# CDR22006-R1-CDs1.pdf Markup Summary

**ELEVATION VIEW  
UPSTREAM HEADWALL DETAILS**

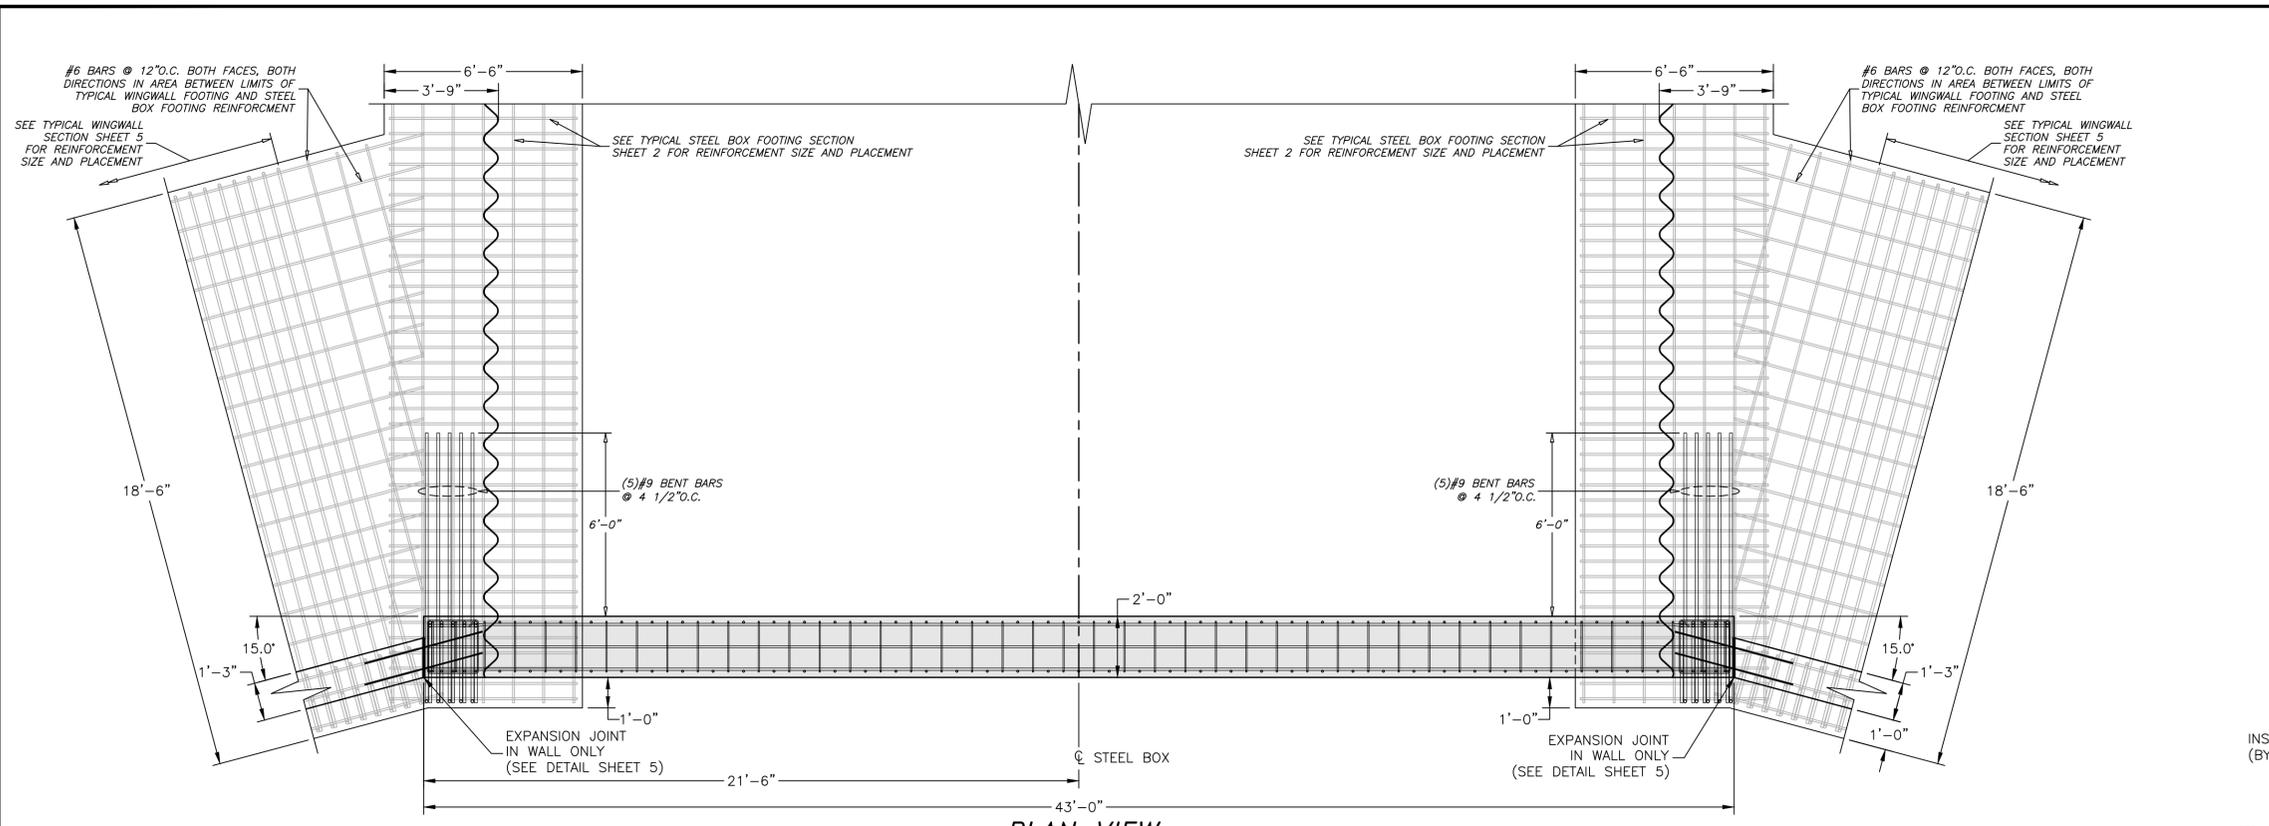
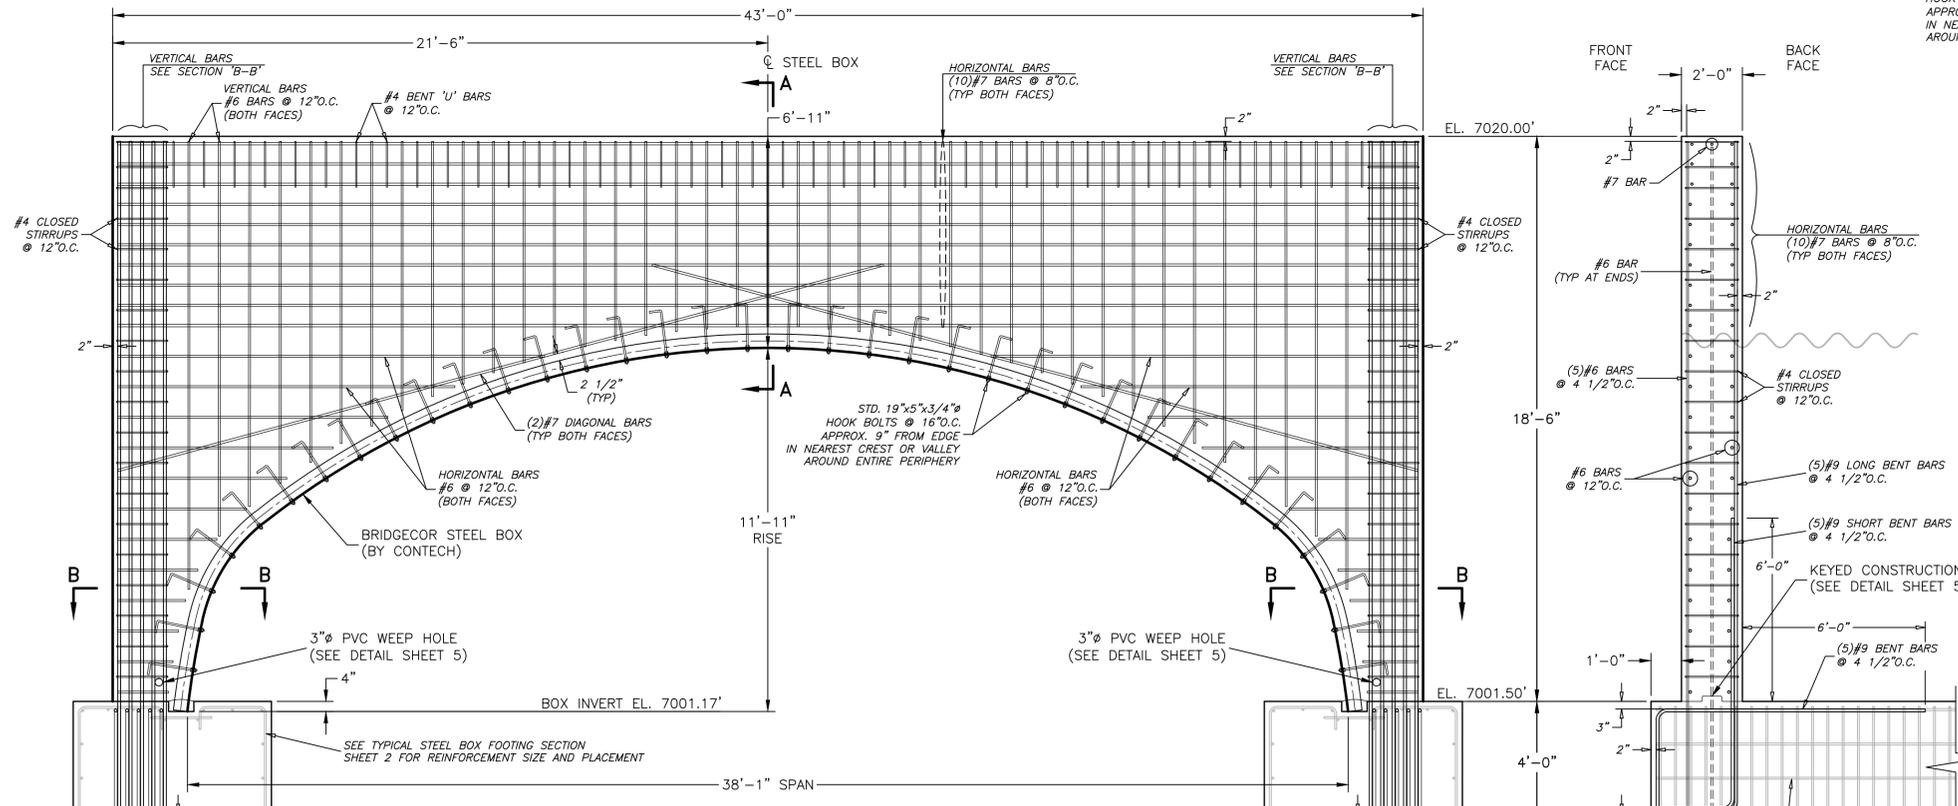
An indication of FG height below TOW at BF would be helpful in this section.

An indication of FG height below TOW at BF would be helpful in this section.

**ELEVATION VIEW  
DOWNSTREAM HEADWALL DETAILS**

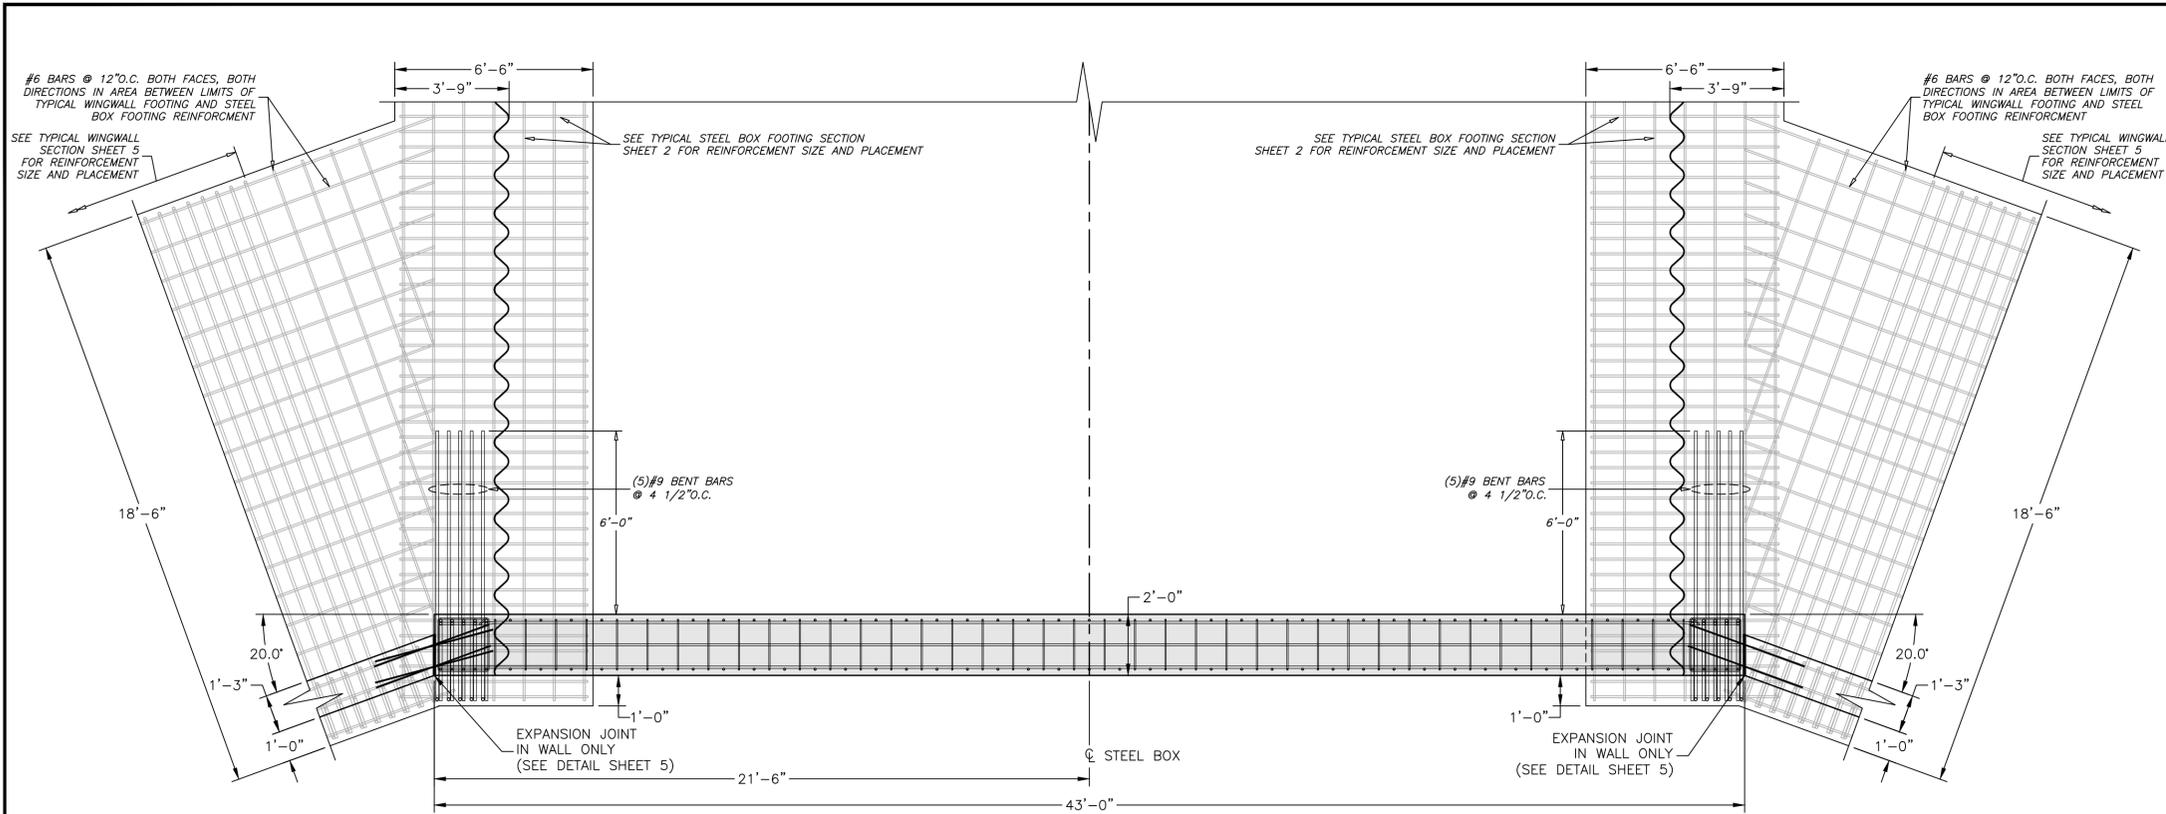
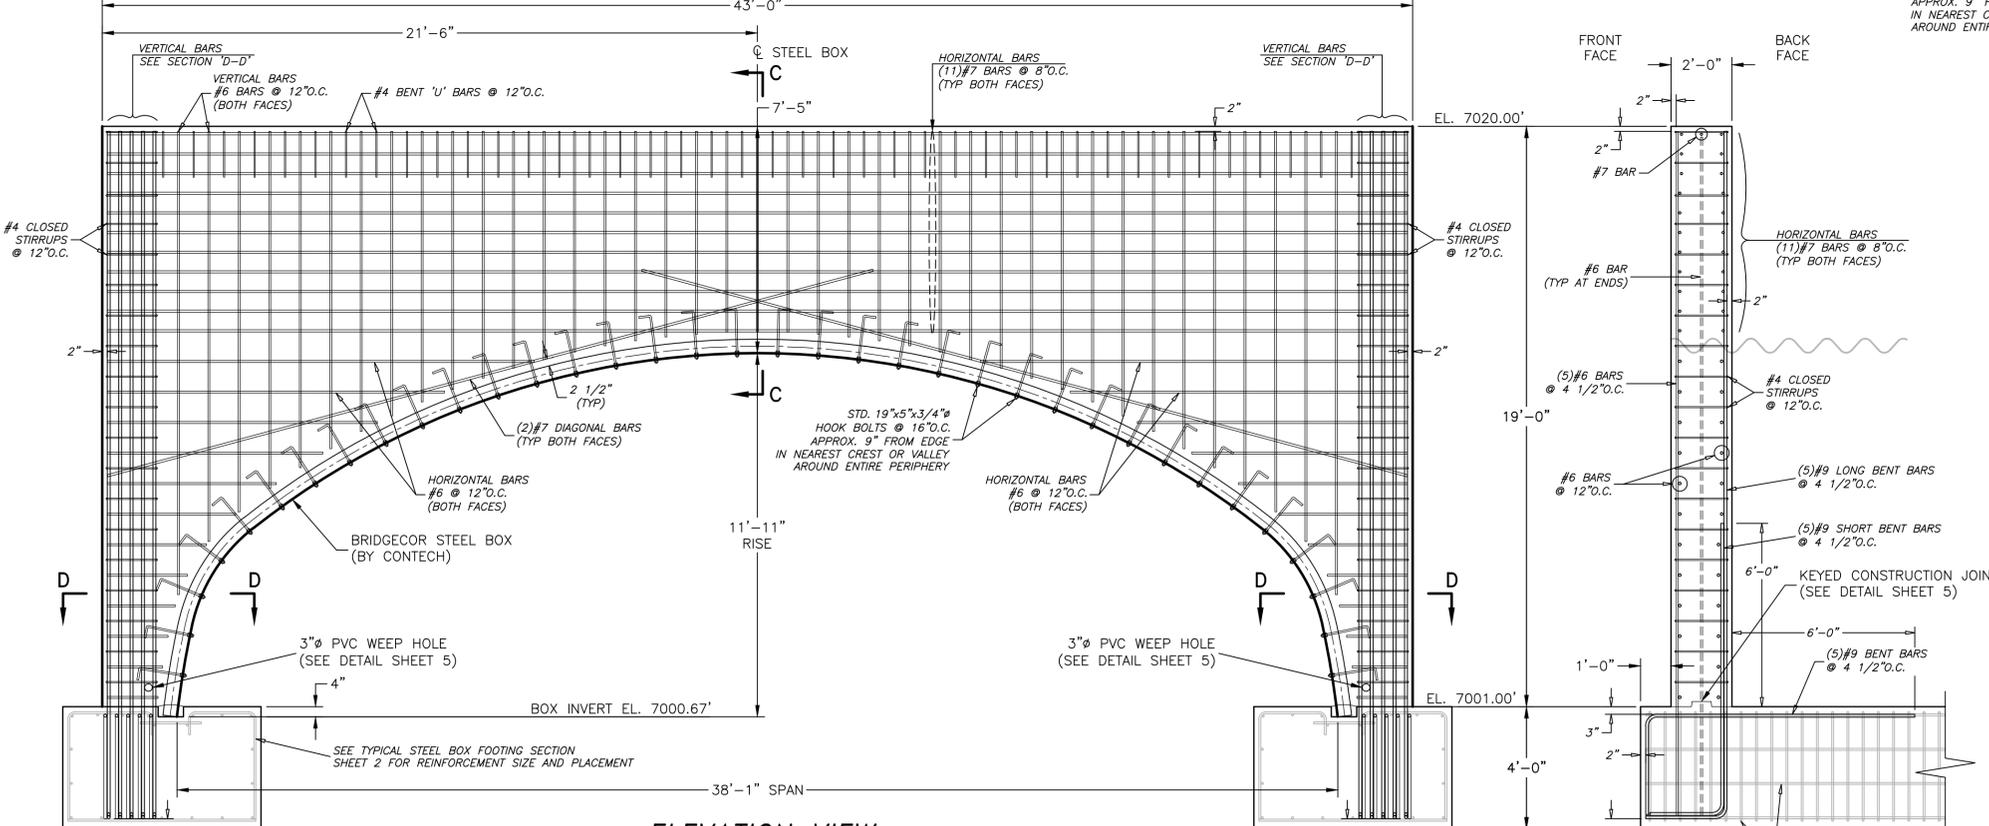
An indication of FG height below TOW at BF would be helpful in this section.

Show minimum grade elevation on downstream side too
